Dyddiad/Date: 15 January 2015

**PROPOSED PORT TALBOT STEELWORKS (POWER GENERATION
ENHANCEMENT) ORDER.**

PROJECT REFERENCE: EN 010062

**WRITTEN REPRESENTATIONS BY THE NATURAL RESOURCES BODY FOR
WALES.**

Figure 14.2.2 River Afan Residual Flow over Greenpark Weir. Run 1 – Scenario 0 Old Baseline without new fish pass residual flows, compared to Run 2 – Scenario 1 Current Operations.

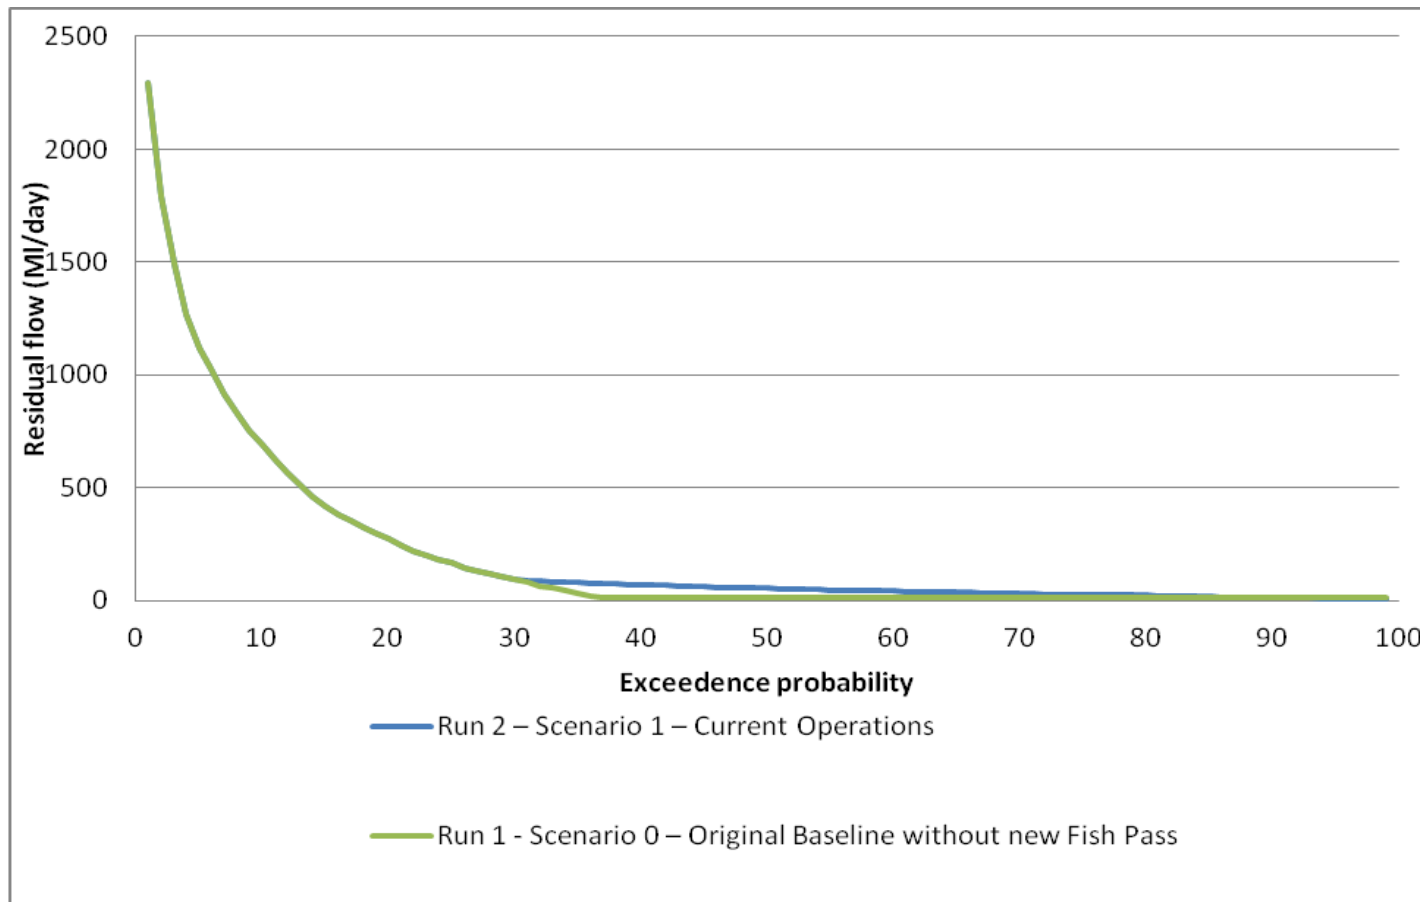
5.40 – Surface Water Environment – Abstraction modelling – Can NRW state whether they have any residual concerns regarding the abstraction modelling.

The abstraction modelling carried out by Halcrow during the original assessment investigated the impact on residual river flows of recent actual rates of abstraction and maximum licensed quantities for Tata Steel. The work carried out by AECOM has shown that the proposed rates of abstraction will not exceed the existing licensed quantities.

NRW is therefore satisfied from the recent modelling that impacts on the residual flows in the River Afan will be no worse than those predicted in the original abstraction modelling carried out by Halcrow and that no further modelling be undertaken.

Figure 14.2.4 Port Talbot Dock simulated level time series plot for whole simulation period. Run 2 – Scenario 1 Current Operations.

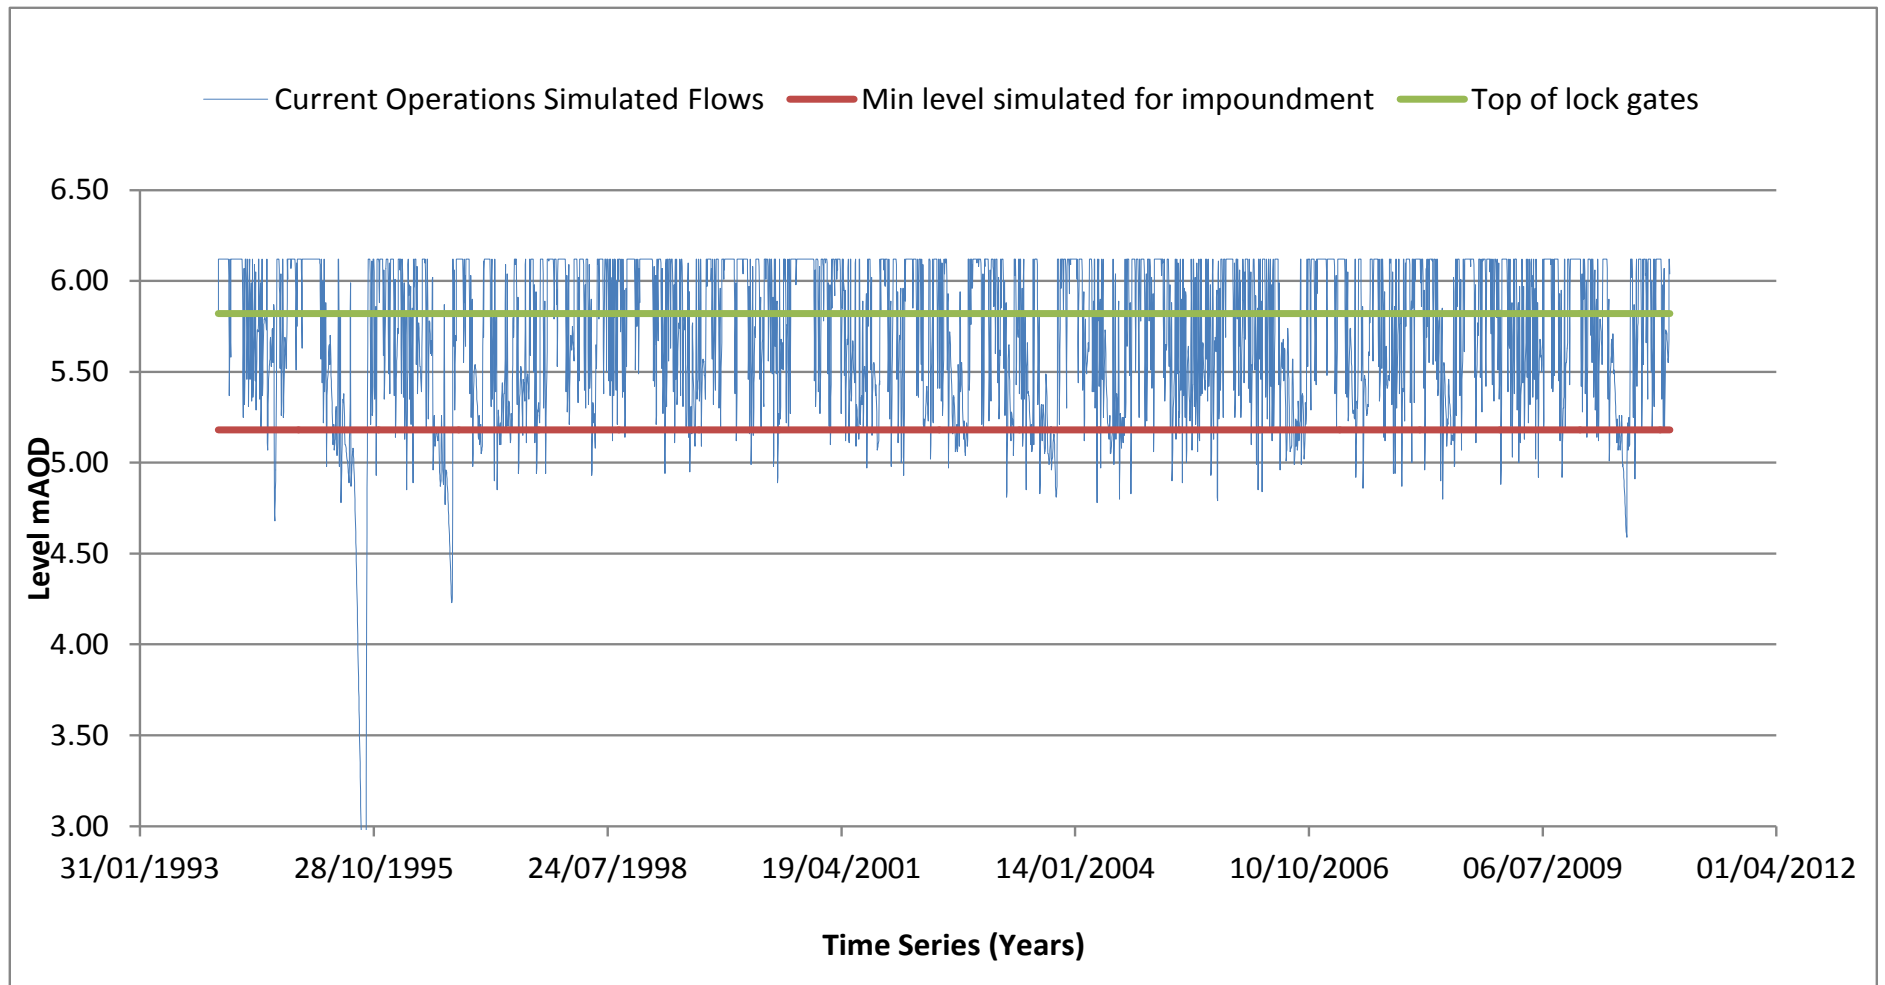
The recent modelling has however shown that there may be some changes to the Dock water levels caused by changes to how water is managed within the system. This is a consideration for ABP in the event that it may affect their current operations.
